From: Terry Prideaux <info@rbatownplanning.co.uk>
Sent: 13 March 2017 14:50
To: Nick Hirst
Subject: : Wheels Brook Farm - 2016/62/93837/W

Title SITE PLAN LAYOUT AS PROPOSED

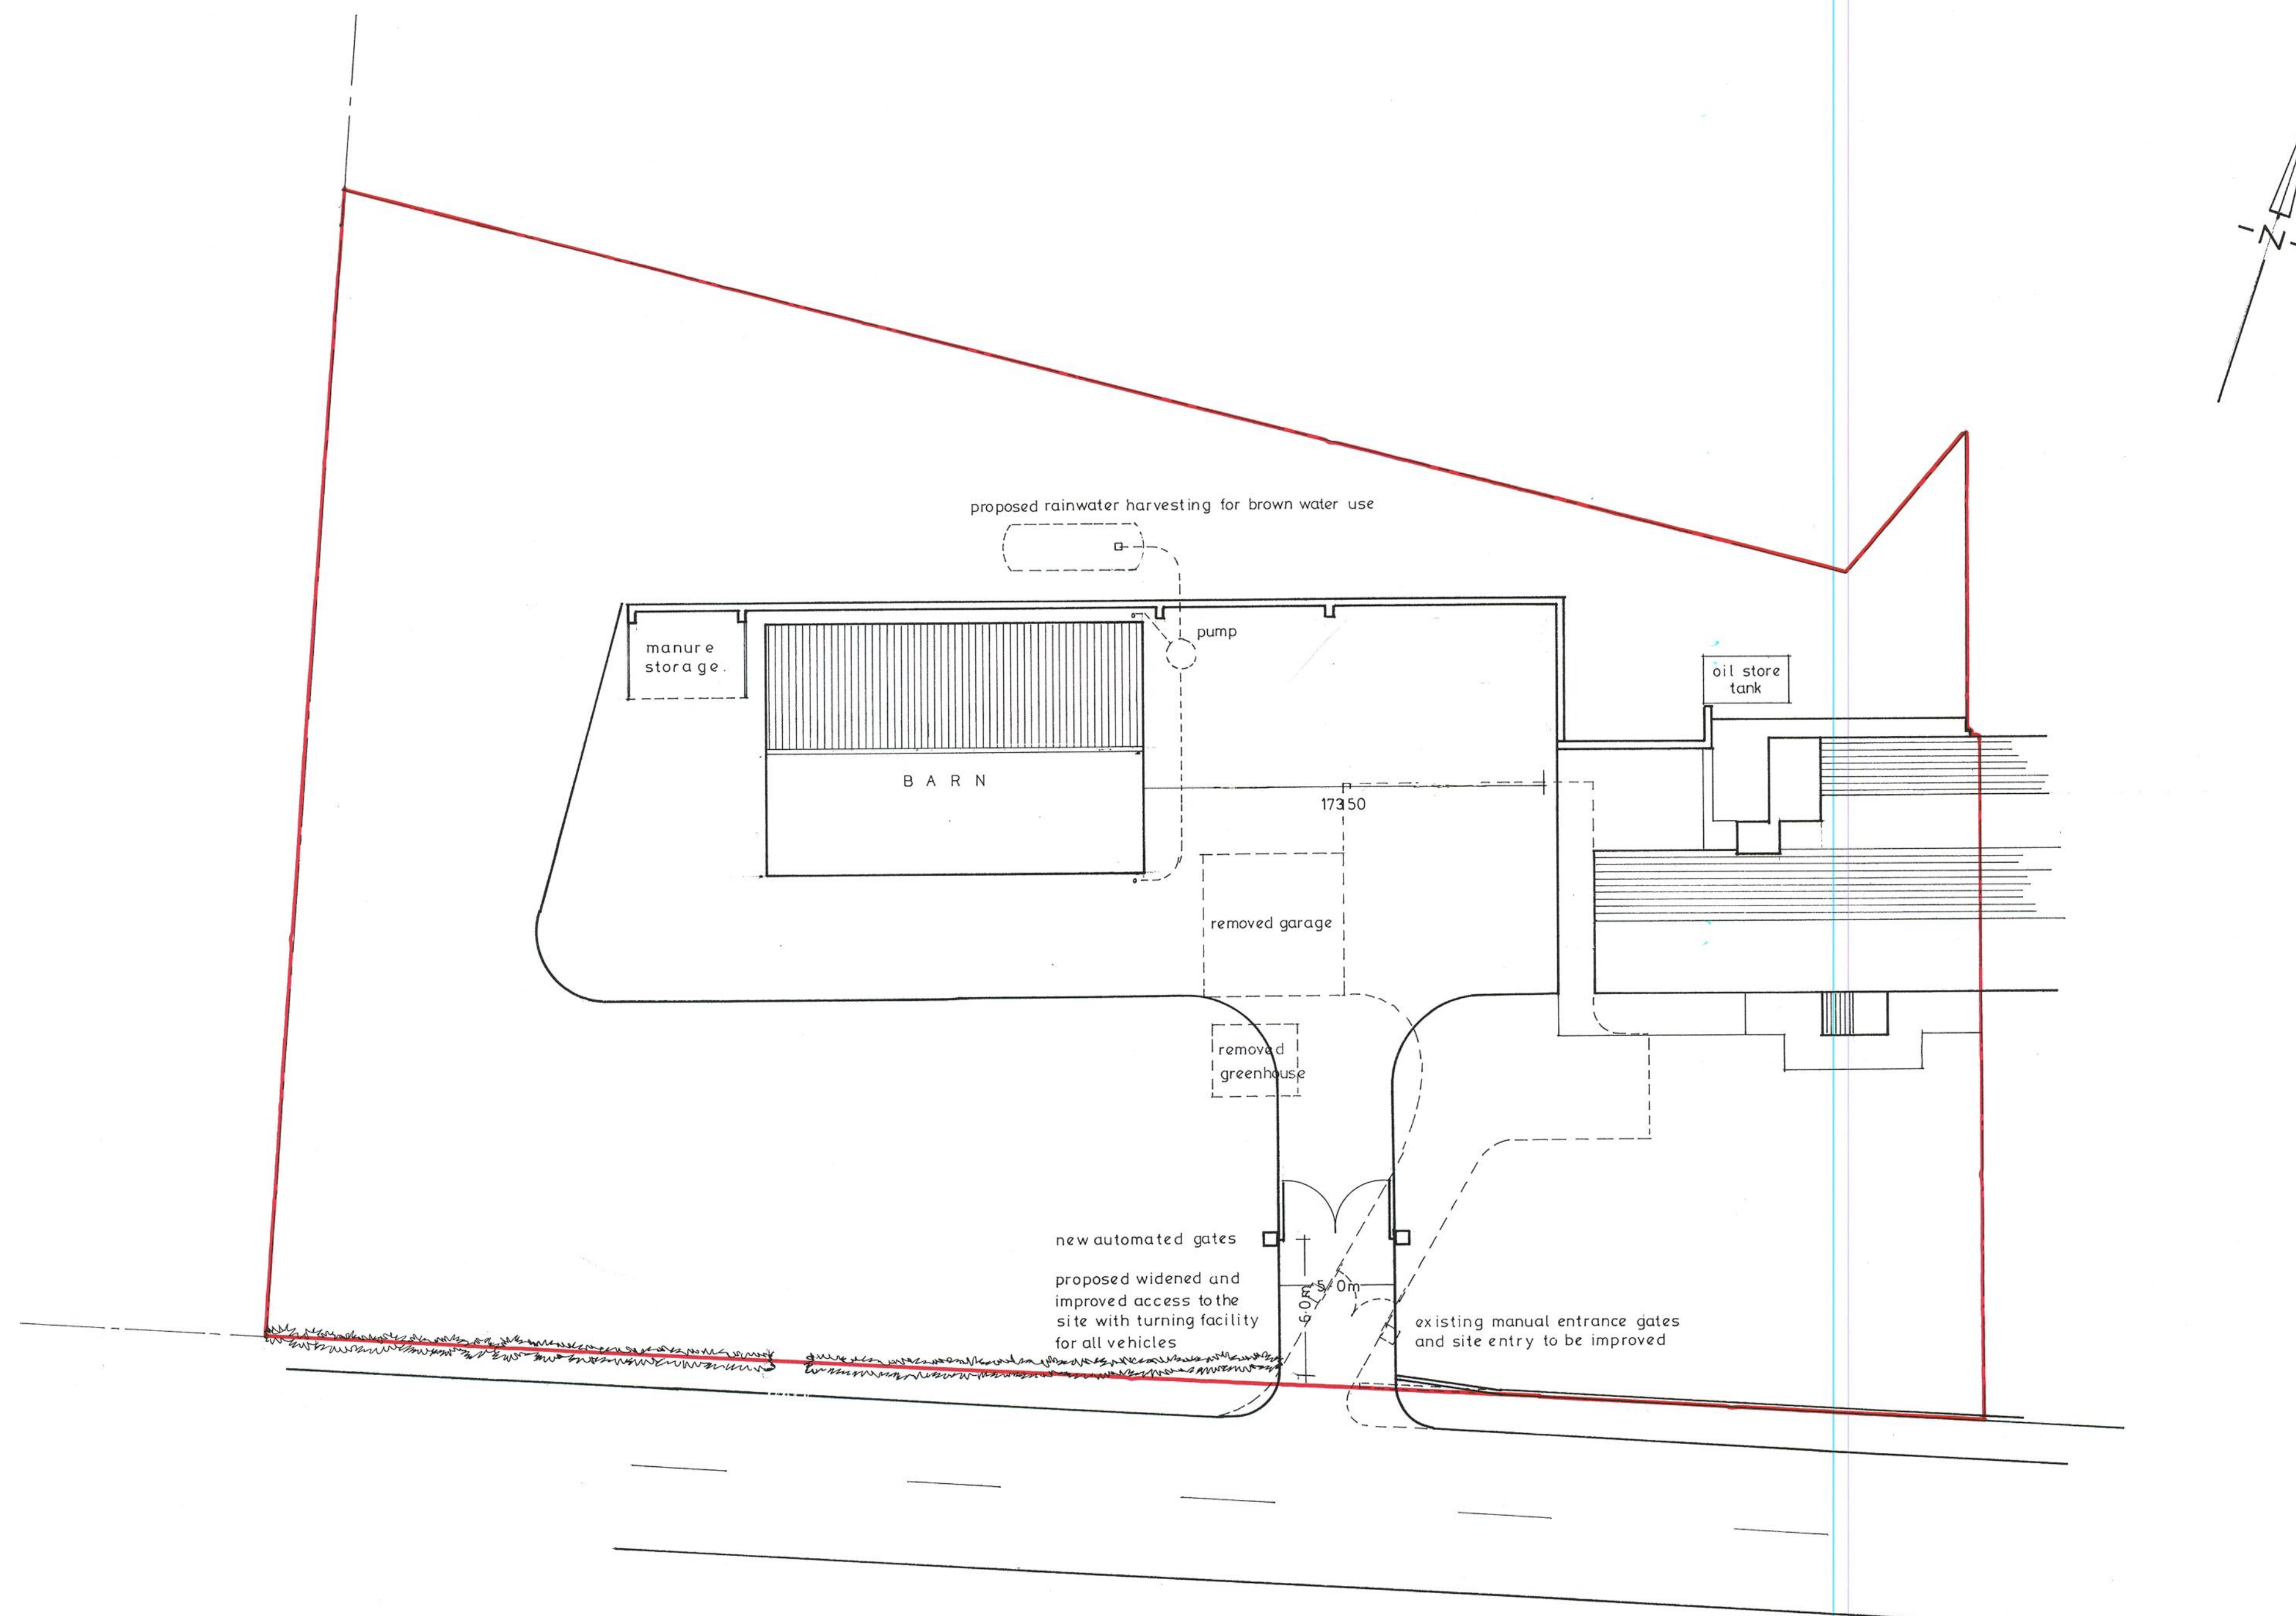
4. Was any other location considered for the barn?

In determining the location of the proposed barn a number of locations were considered by the applicant all of which were in prominent and locations isolated from the main dwelling house, these were discounted on Green Belt considerations. Whilst the proposed location requires significant engineering works, this location was identified as most suitable in terms of protecting the open character of the location and with the less intrusive reuse of the material excavated being distributed over the existing area evenly. The proposed location reuse land that over the passage of time has been used for garden space inappropriate to the green belt, the proposed use of agricultural is an appropriate use and more reflective of the areas character.

Title FLOOR PLAN AND ELEVATIONS AS PROPOSED

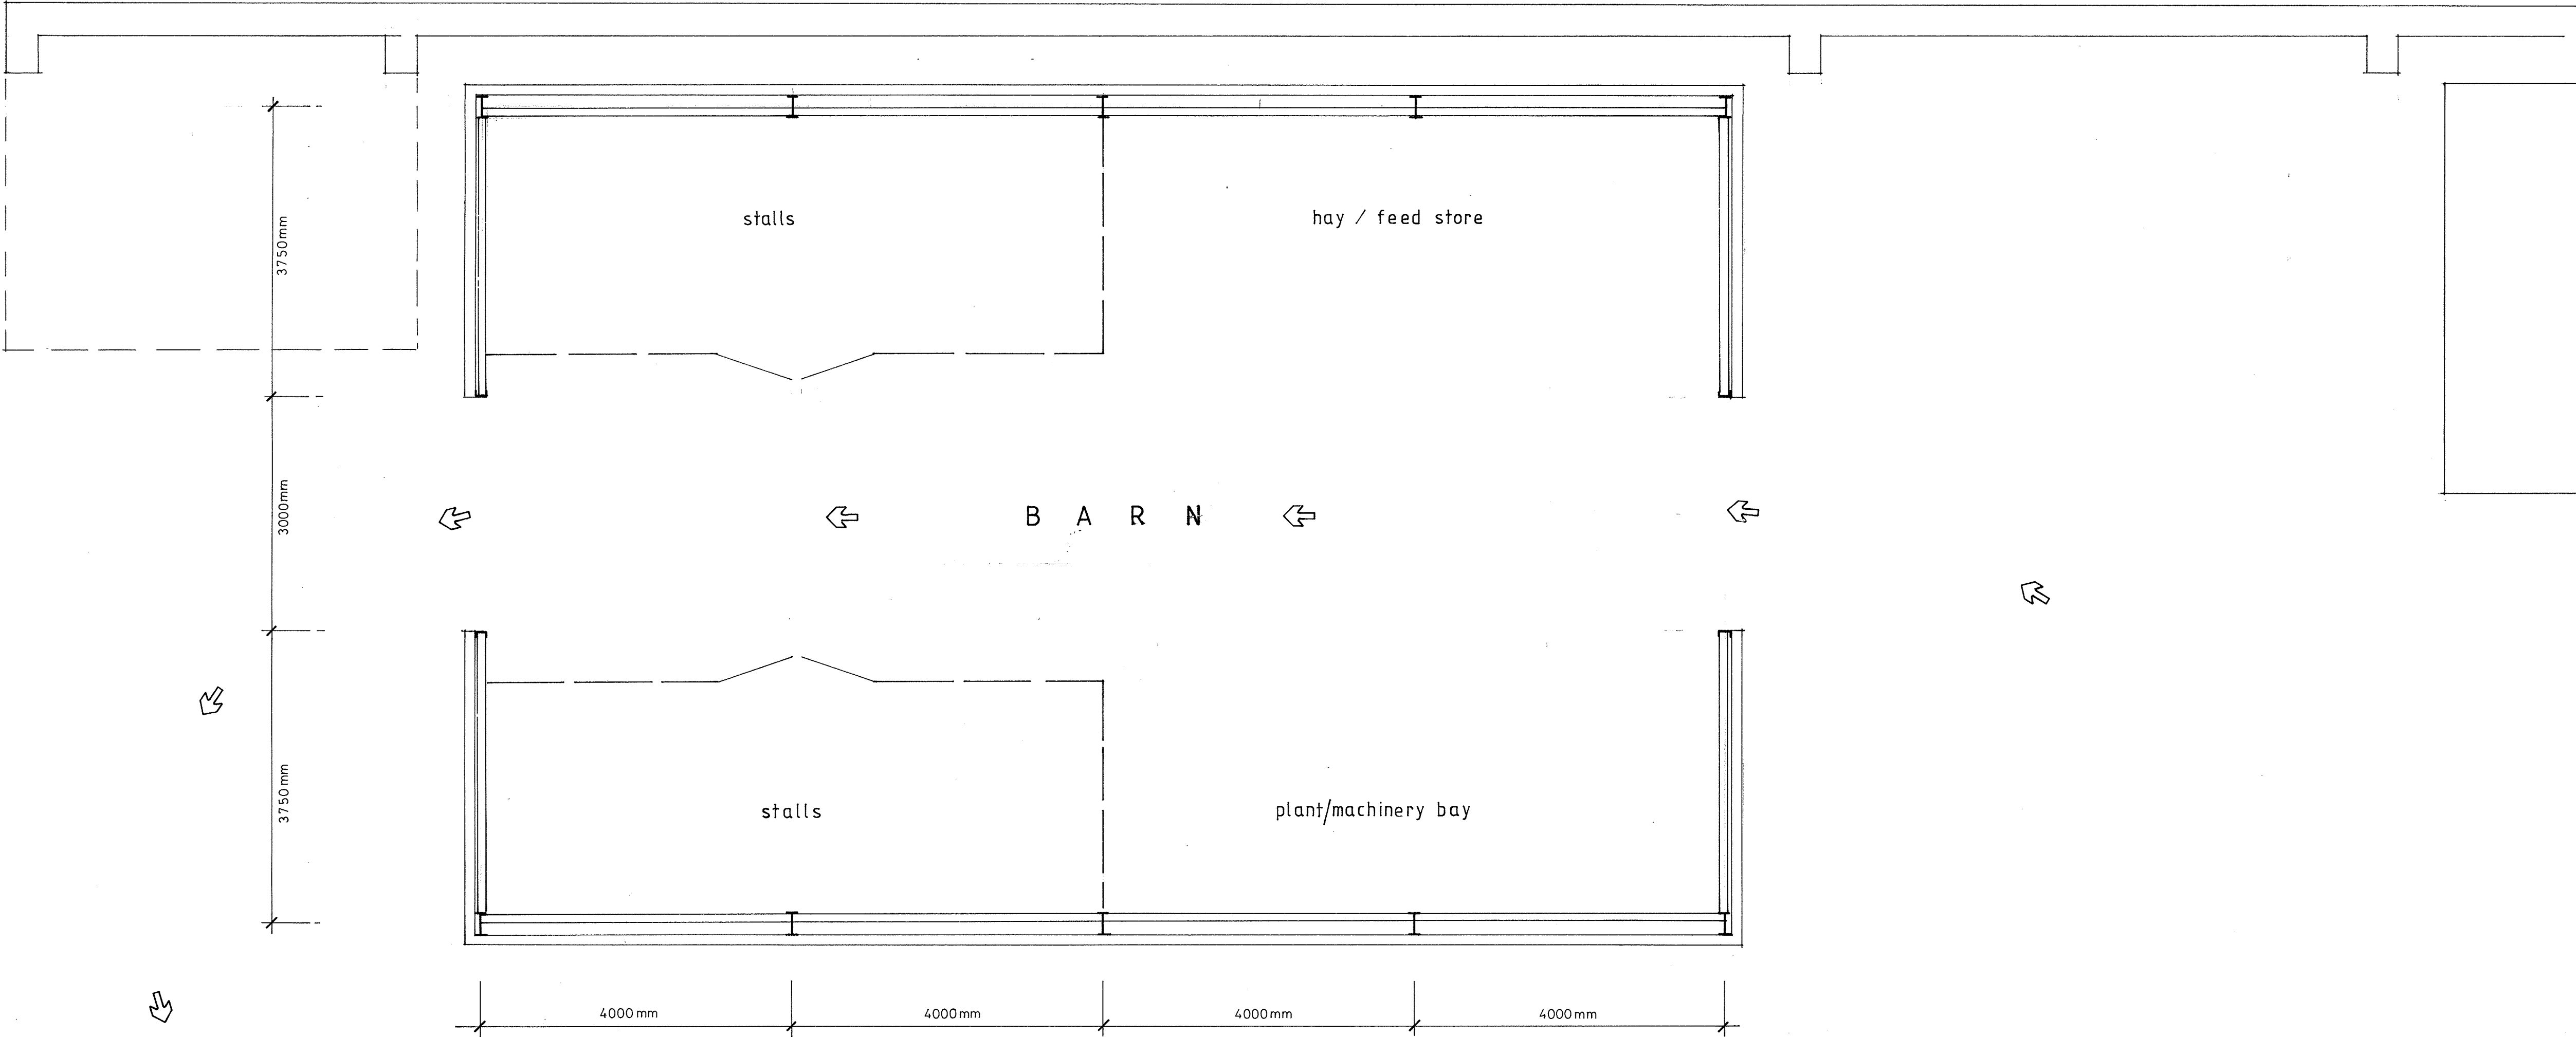
2. Why does the building have to be the size it is, has it been designed to comply with the relevant regulations/specifications?

The building has been designed to accommodate the above specifications in relation to sheep pens, the remining space is to accommodate the equipment necessary to maintain and improve the land condition. In terms of floor space not only the storage of materials is important but the free and safe movement around equipment is equally important to maintain good Health and Safety practices, farm machinery is extremely dangerous and its correct storage and maintenance is highly important. The proposed floor area provides a level of space to comply with health and safety practices. Whilst some hay will be provided form the land the majority will need to be bought in and stored in a dry area, to maximise storage the building has been design to a height that will accommodated 3/4large bales of hay/straw to minimise the impact upon floor space, in addition the height is also necessary to accommodate the sites tractor.
